Date:	12/6/16	Review Agency:	State Engineer
File Number:	SF-16-021, PUDSP-16-004	Reviewer:	_____
		Project Manager:	Nina Ruiz (719) 520-6313
Send response comments to: <u>DSDcomments@elpasoco.com</u>			
Project Name:	North Bay at Lake Woodmoor Final Plat, Preliminary Plan, Planned Unit Development		
Request:	A request by Lake Woodmoor Holdings LLC for a final plat to create 28 townhome lots, and 5 tracts on a 7.23 acre parcel presently zoned R-4 (obsolete). A PUD/preliminary plan is being processed concurrently. The applicants have requested a CLOMR from FEMA to realign the floodplain to that which is shown on the final plat drawing.		
Commissioner Dist:	1		
Tax ID# (s):	71114-04-111, 71114-00-007

Re: North Bay at Lake Woodmoor – PUD Development Plan and Final Plat

Subject: Northbay at Lake Woodmoor, SF-16-021, Review 1

Project No.:	15073
Date:	November 8, 2016
Design:	NRK
Drawn:	CAD
Check:	AWMc
Revisions:

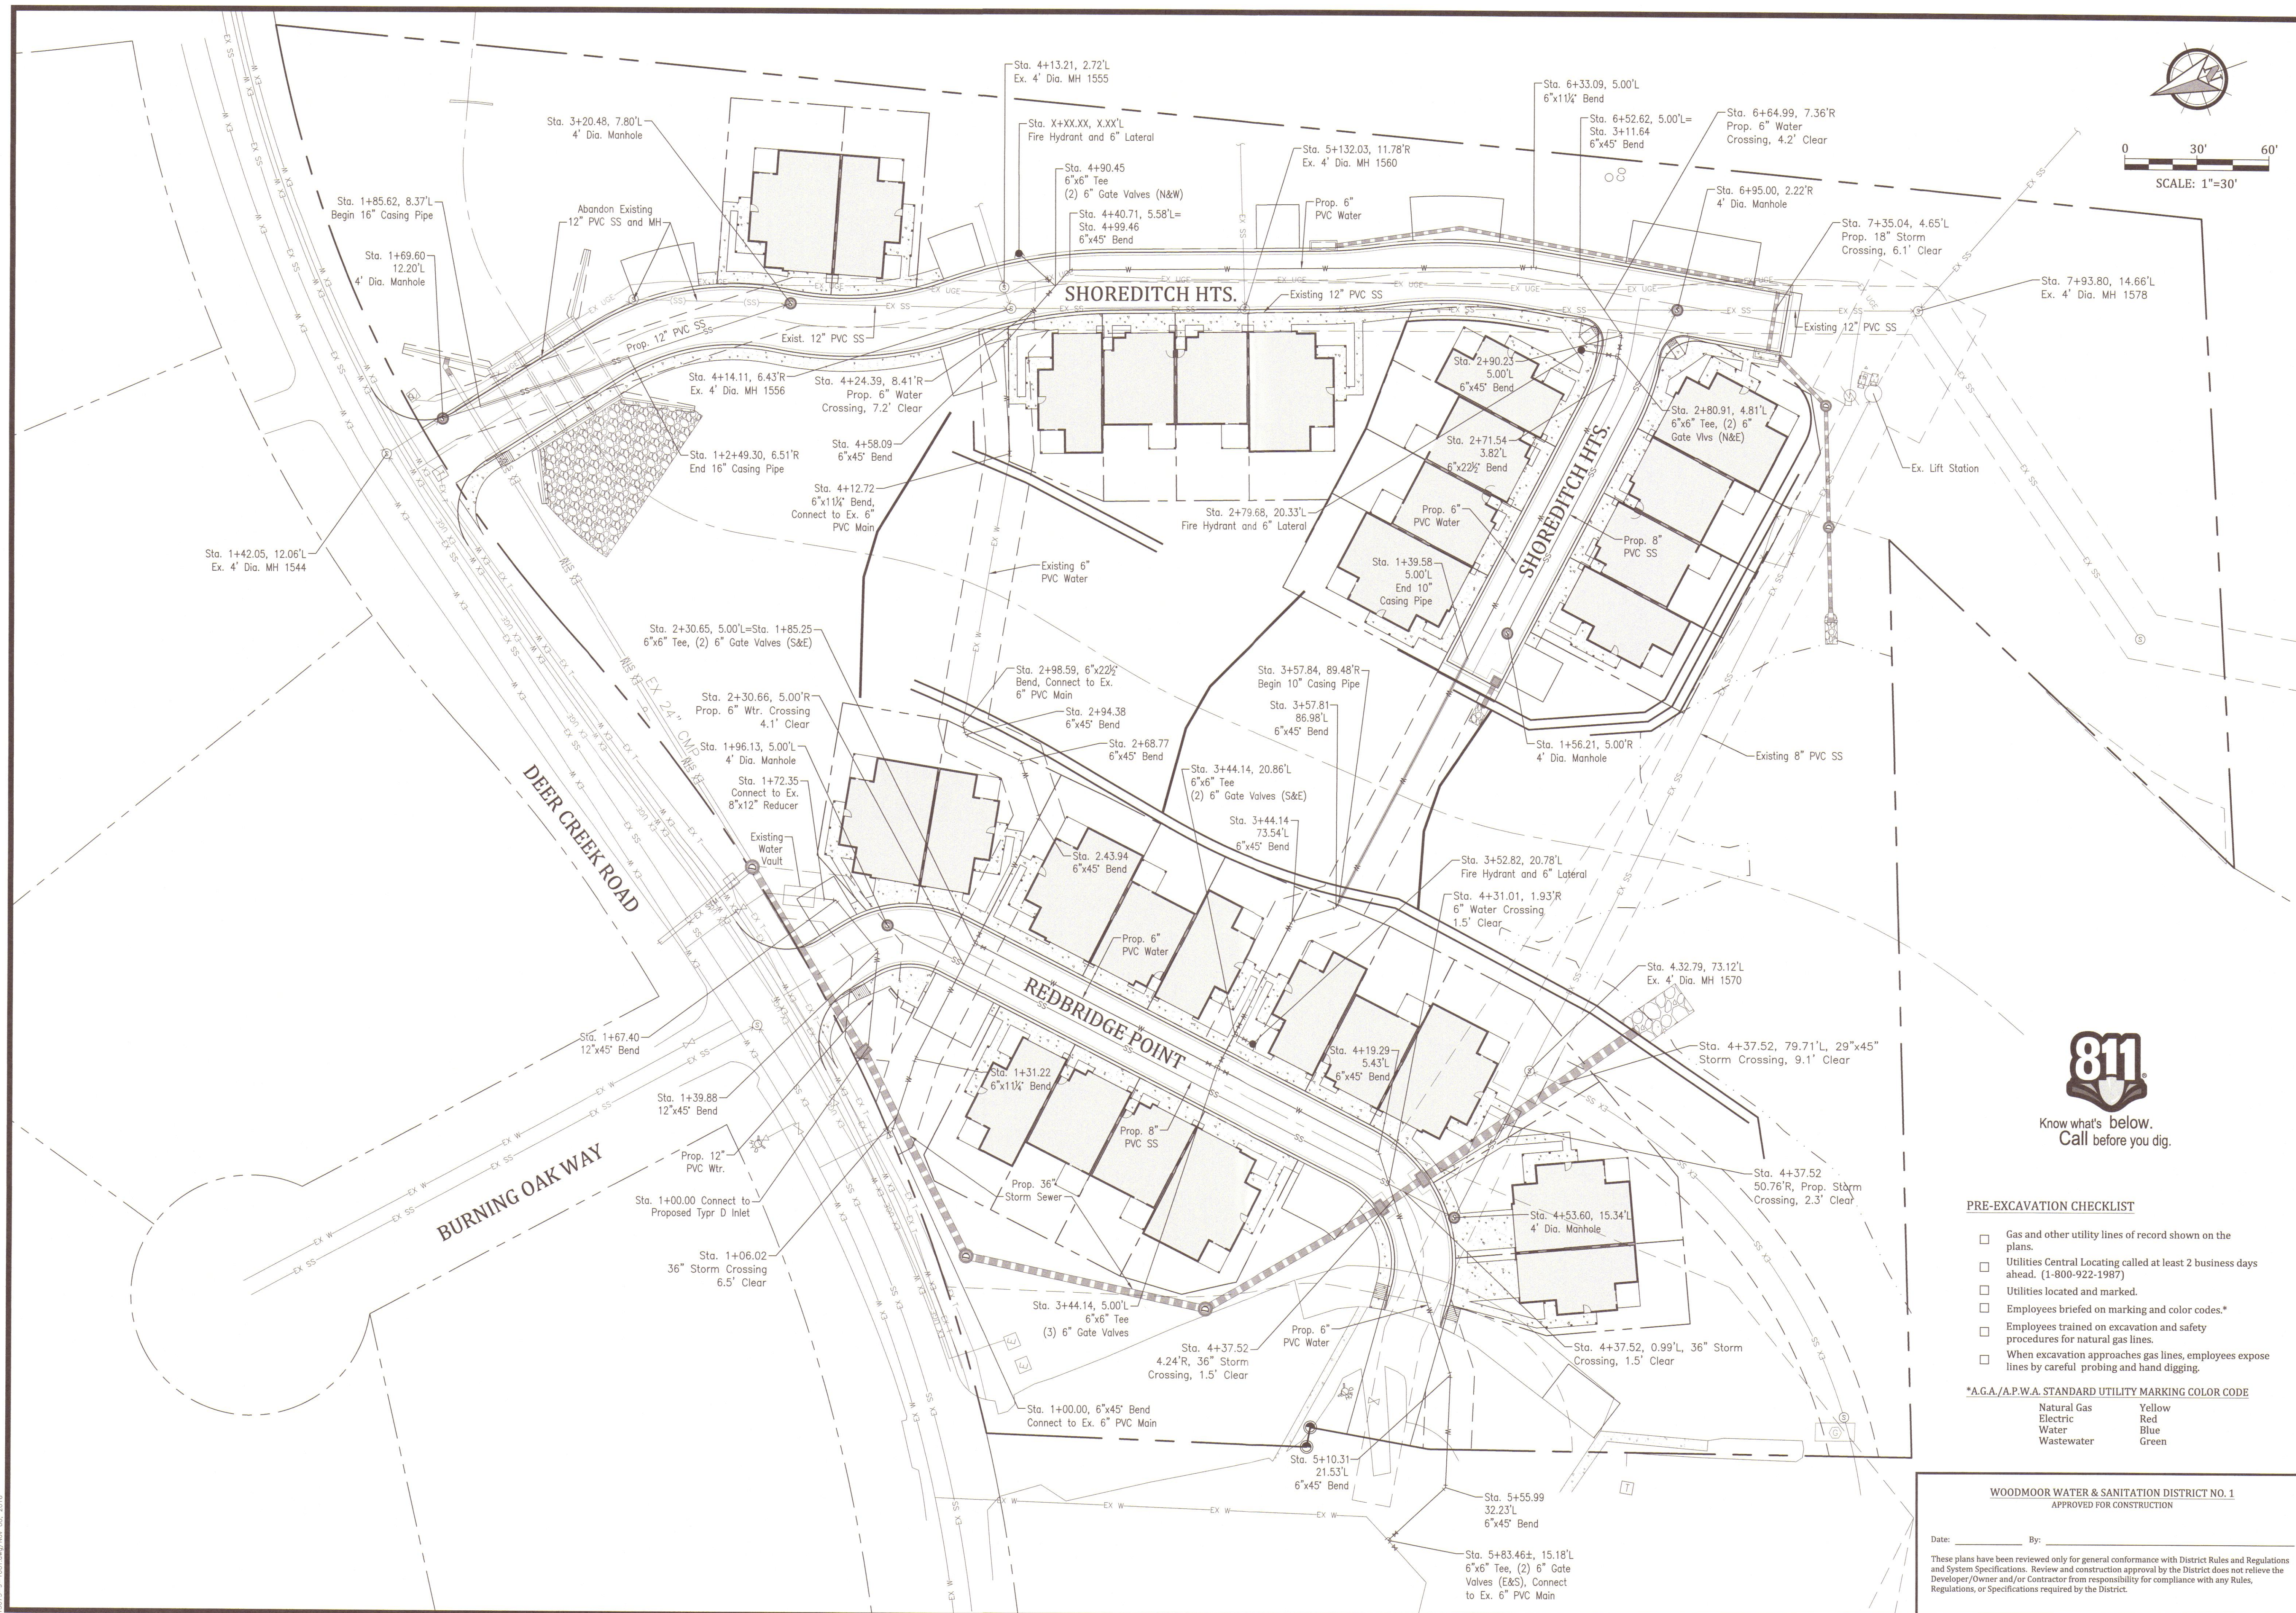
3. Roadway P&P sheets (6 & 7)
 - a. Provide the stationing labels along the centerline on the plan view.
 - b. Provide the roadway line data.
 - c. Label the proposed and existing grade on the profile view.

- d. Extend the existing ground profile at Sta 4+91 on Redbridge Point. If the connection to existing ground has an algebraic difference in grade equal to or greater than 1.0%, vertical curve is required. Also, the grade should not exceed 5% due to ADA accessibility.

- e. Include the A.D. and K value in the vertical curve label.
 - f. Revise the pedestrian ramp layout at the hammerhead intersection per ECM detail SD_2-41.
